WEST SUSSEX COUNTY COUNCIL CONSULTATION

TO:	Arun District Council - FAO: Simon Davis
FROM:	WSCC - Highways Authority
DATE:	16 November 2020
LOCATION:	Land to West of Hook Lane, Westergate, PO20 3TE
SUBJECT:	AL/79/20/OUT Outline planning application with some matters reserved (Layout, Scale, Appearance and Landscaping are to be determined as reserved matters) for the construction of 10 No. dwellings & the creation of a new vehicular & pedestrian access on to Hook Lane. This application is a Departure from the Development Plan.
SITE VISIT:	16/11/2020
RECOMMENDATION:	More Information

West Sussex County Council, in its capacity as the Local Highway Authority (LHA), have been consulted on outline application with matters of access sought for 10 x dwellings (2 x 2-bed, 3 x 3-bed, 5 x 4-bed) on land west of Hook Lane.

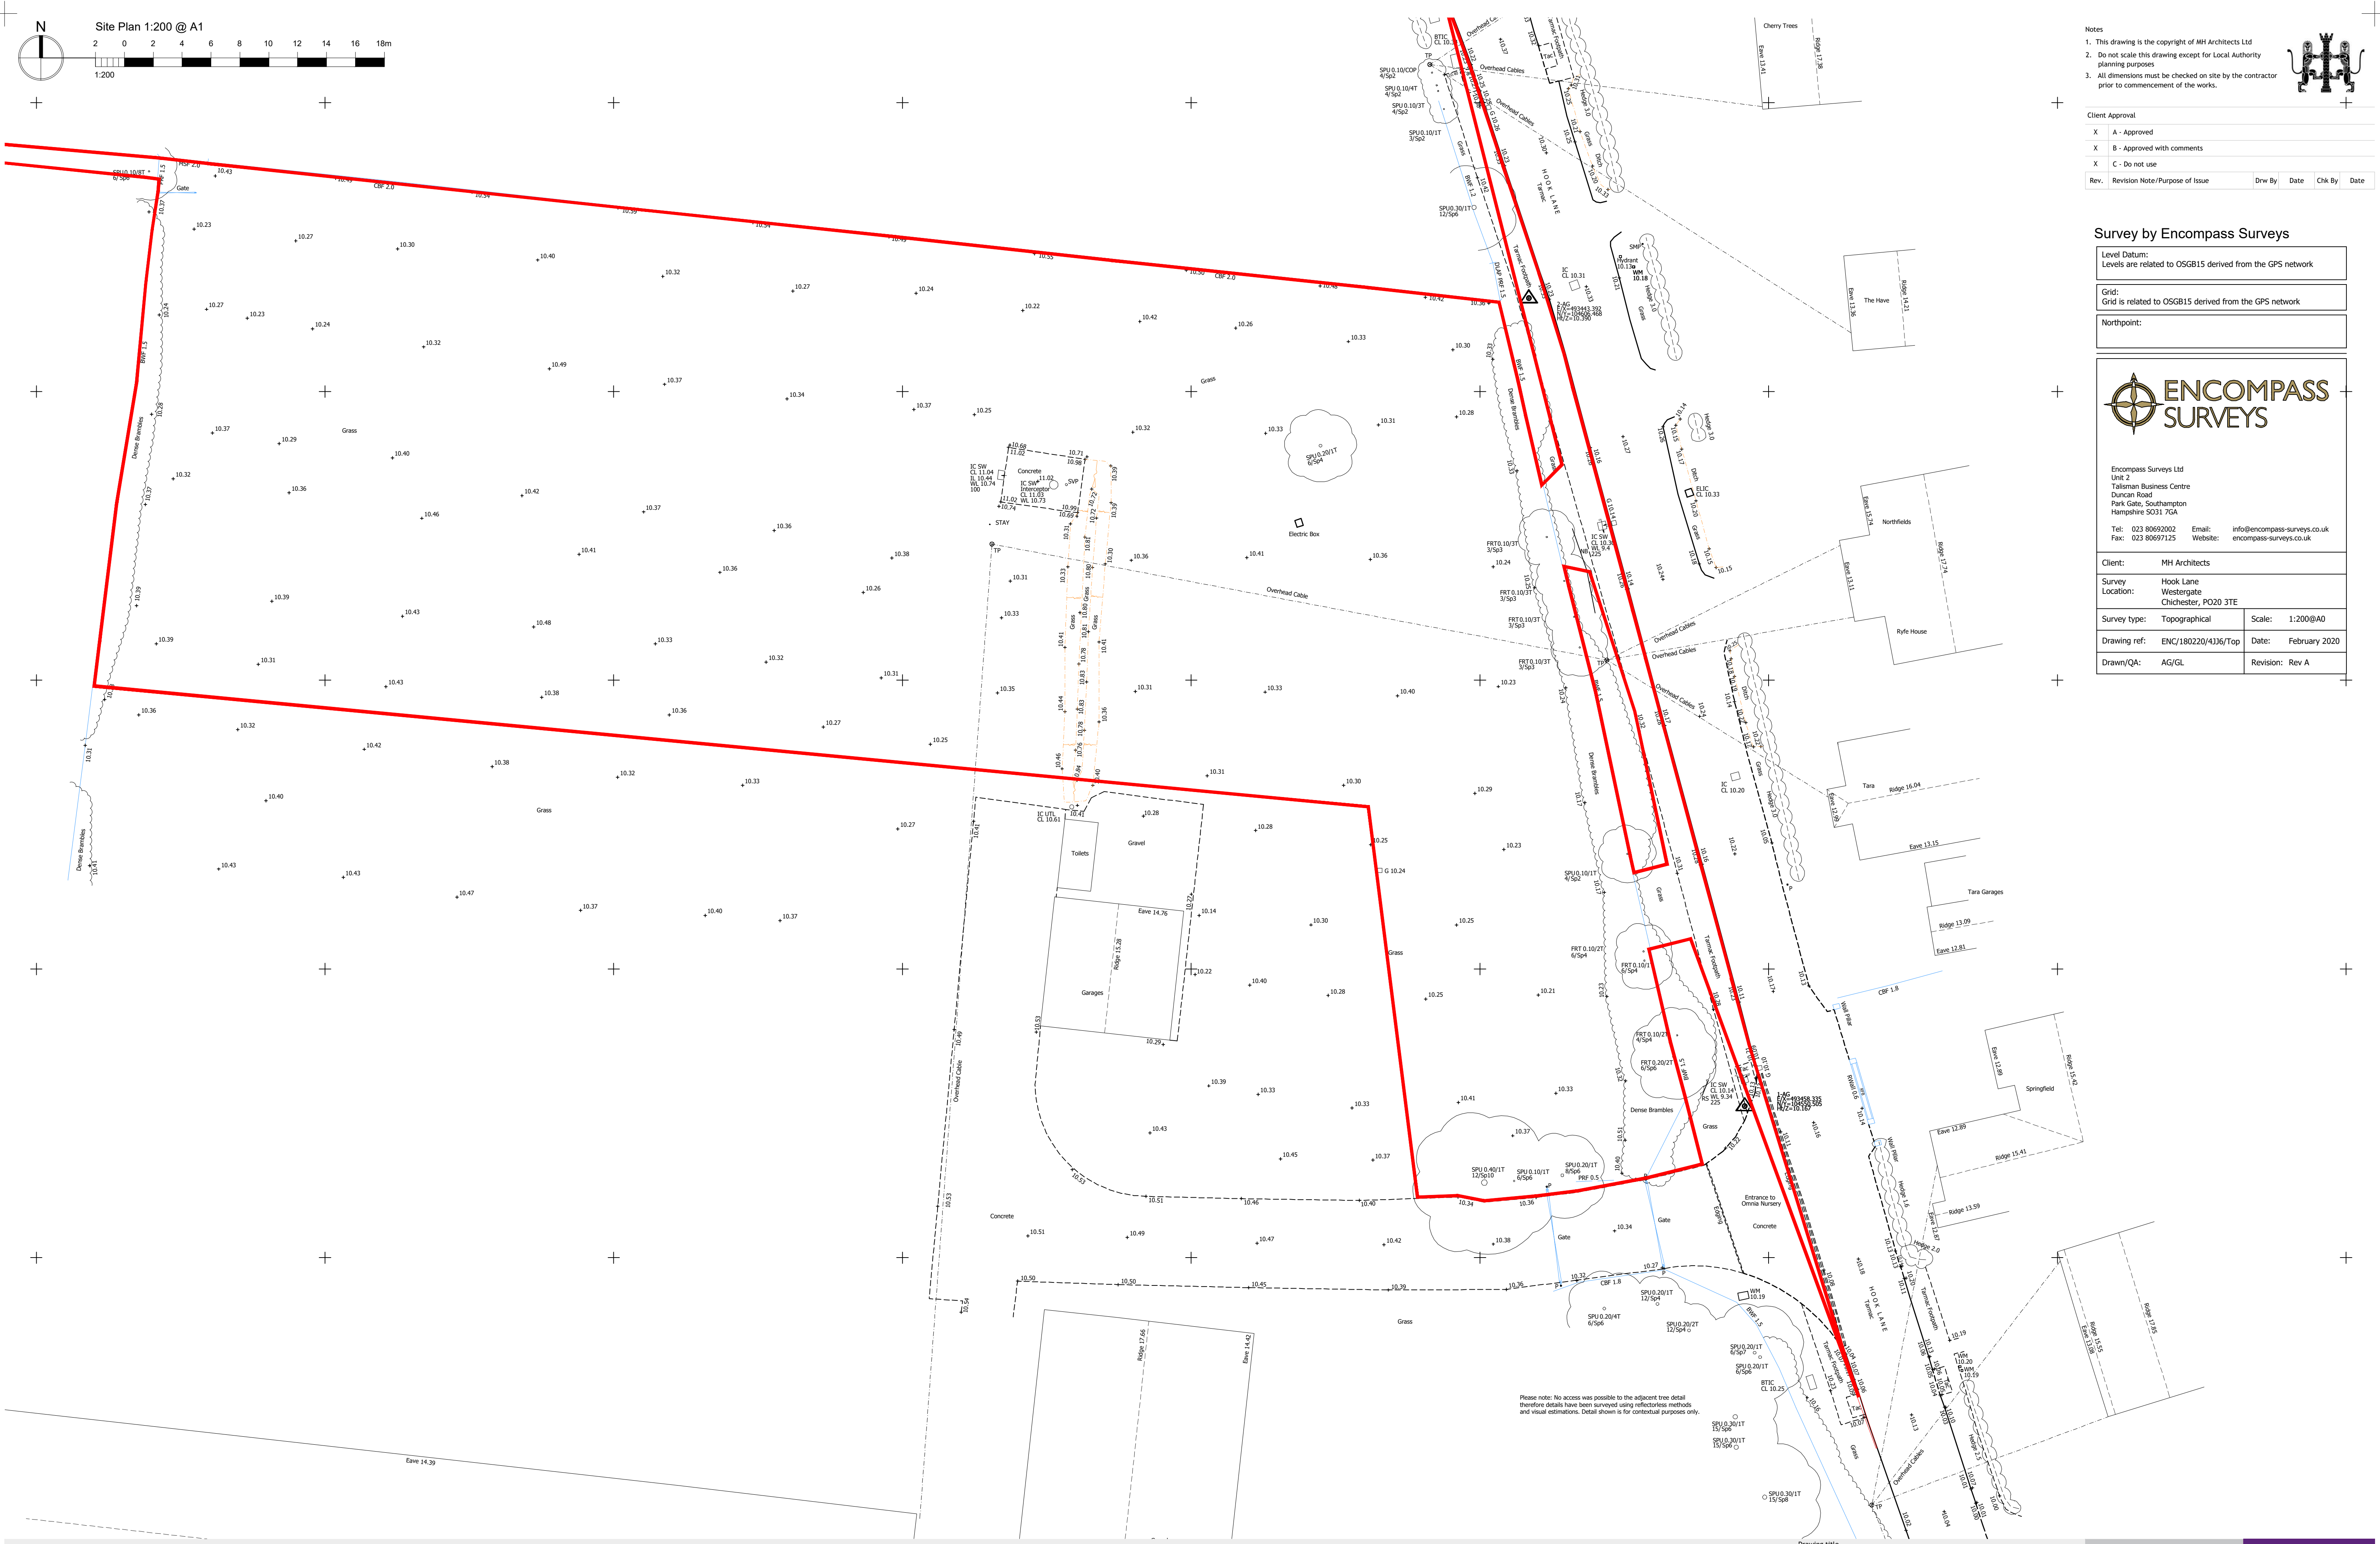
Within the site the carriageway reduces to approx. 3.9m which would not allow 2 x cars to pass. It is presumed this is a traffic calming feature which will reduce speeds within the site and it is considered that a car could wait clear of Hook Lane and give way where required. Footway appears to extend in to the site from the site access and transition to shared surface after passing plots 3 & 4. This is considered appropriate for the anticipated traffic volumes within the site and further detail would be agreed at detailed design stage.

Whilst car parking would be assessed at reserved matters stage the LHA have nonetheless reviewed the proposed arrangements. Arun Supplementary Planning Document (SPD) sets out parking requirements for new developments. Within zone 2, 4-bedroom dwellings require 3 x spaces each. Whilst 4 x 4-bedroom units are shown with 2 x spaces each it is considered that space is available within the site for overspill parking. The 3 and 2-bedroom units should be provided with 2 x spaces each and these are shown within the site. The SPD sets out that garages of sufficient size will count toward 0.5 space and thus the parking provision falls short of the anticipated demand. The LPA may wish to consider this from an amenity point of view. Visitor parking will be provided at 4 x spaces which exceeds the SPD requirement.
